From: Russell Hand <RHand@cityofsydney.nsw.gov.au>
Sent: Wednesday, 3 June 2015 12:11 PM
To: Sara Roach
Cc: David McNamara
Subject: Barangaroo Central Waterfront Promenade - Section 96

I write in relation to Barangaroo Delivery Authority's proposed Section 96 to the Barangaroo Central Waterfront Promenade Public Domain.

# BARANGAROO | Promenade Section

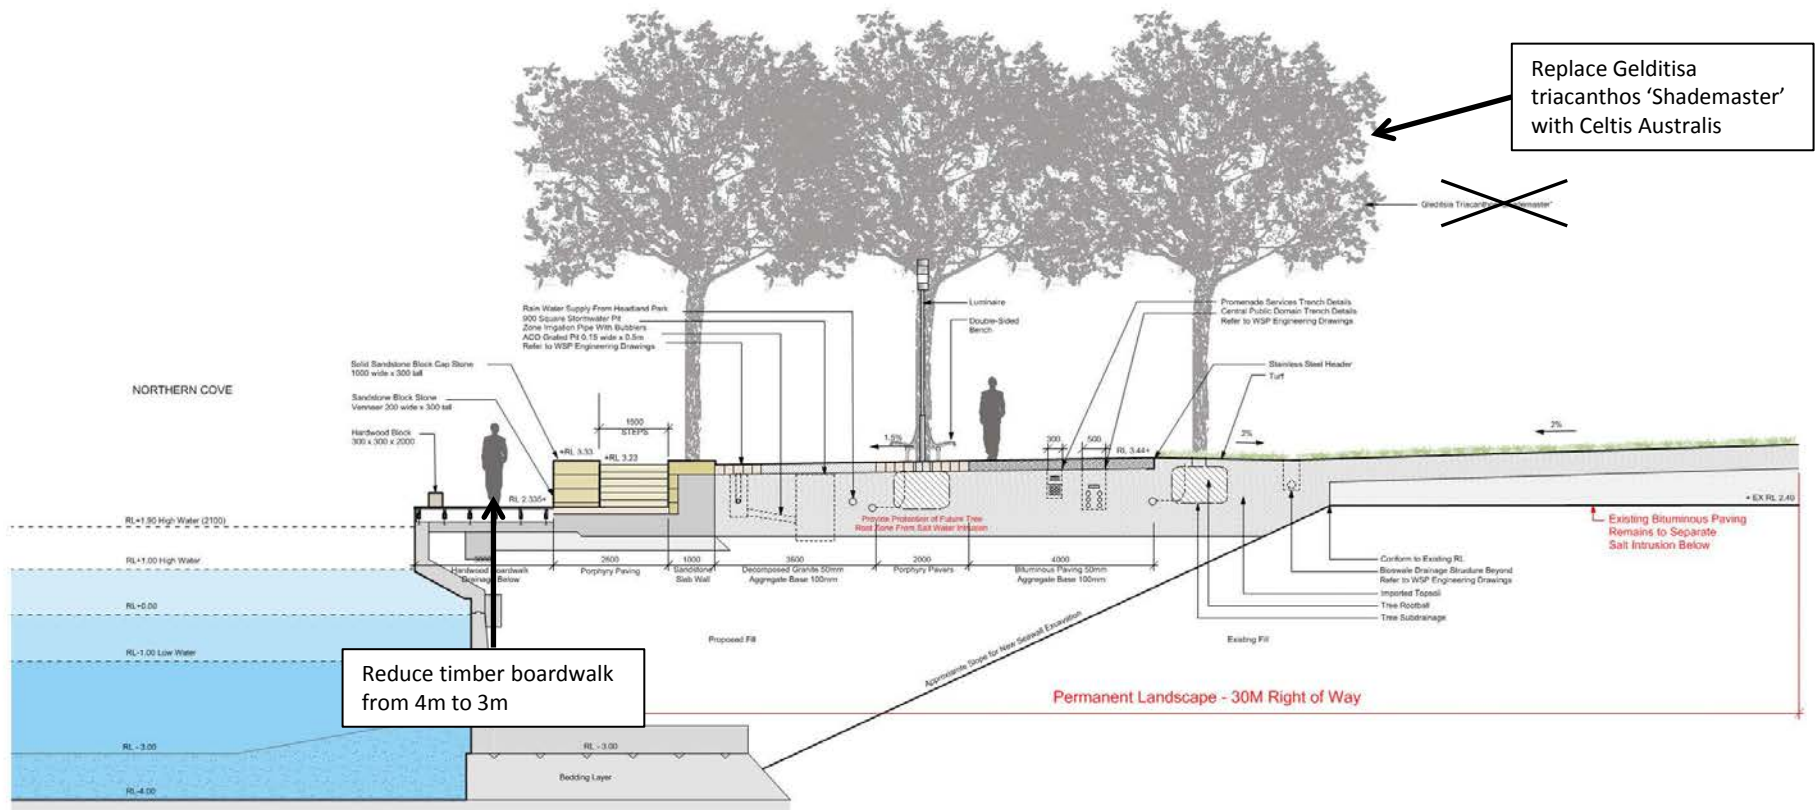
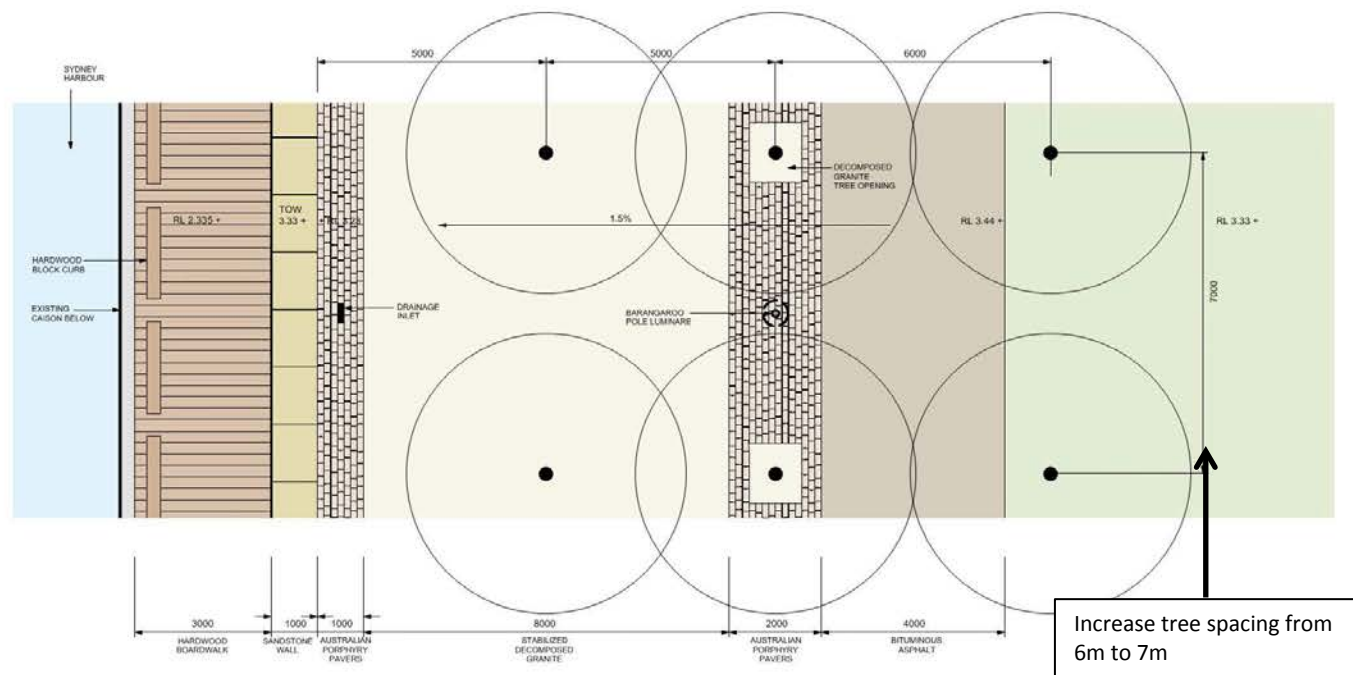
The City raises issue in relation to the reduction in the width of the foreshore timber boardwalk from 4m to 3m.

The modification suggests that the reduced width is required so that the Central Precinct is coordinated with the future Barangaroo South width. However, the documentation we hold shows an approved 4m wide boardwalk for Barangaroo South Stage 1A. We are not aware of the proposed width for Stage 1B at this point. Clarification is required regarding the justification for reducing the boardwalk. Pre-empting a future scenario created by the MOD 8 hotel and casino foreshore arrangements would be premature. Unless there is a genuine justification, the reduced width should not be supported. The reduced width may be problematic for the number of users along the waterfront. Although the boardwalk is billed as a secondary path subservient to the main walking and cycle path above it, the walkway is nevertheless going to be highly attractive. The reduced width also contributes to the walkway appearing out of scale with the sheer length of the waterfront.

The reduced 3m width does not reflect the true width available to users. The 3m is to be further reduced to approximately 2.4m once obstacles like the proposed hardwood blocks are included. In the event that 3m is supported by the Department, the true width available to users should be 3m for the volume of users expected.
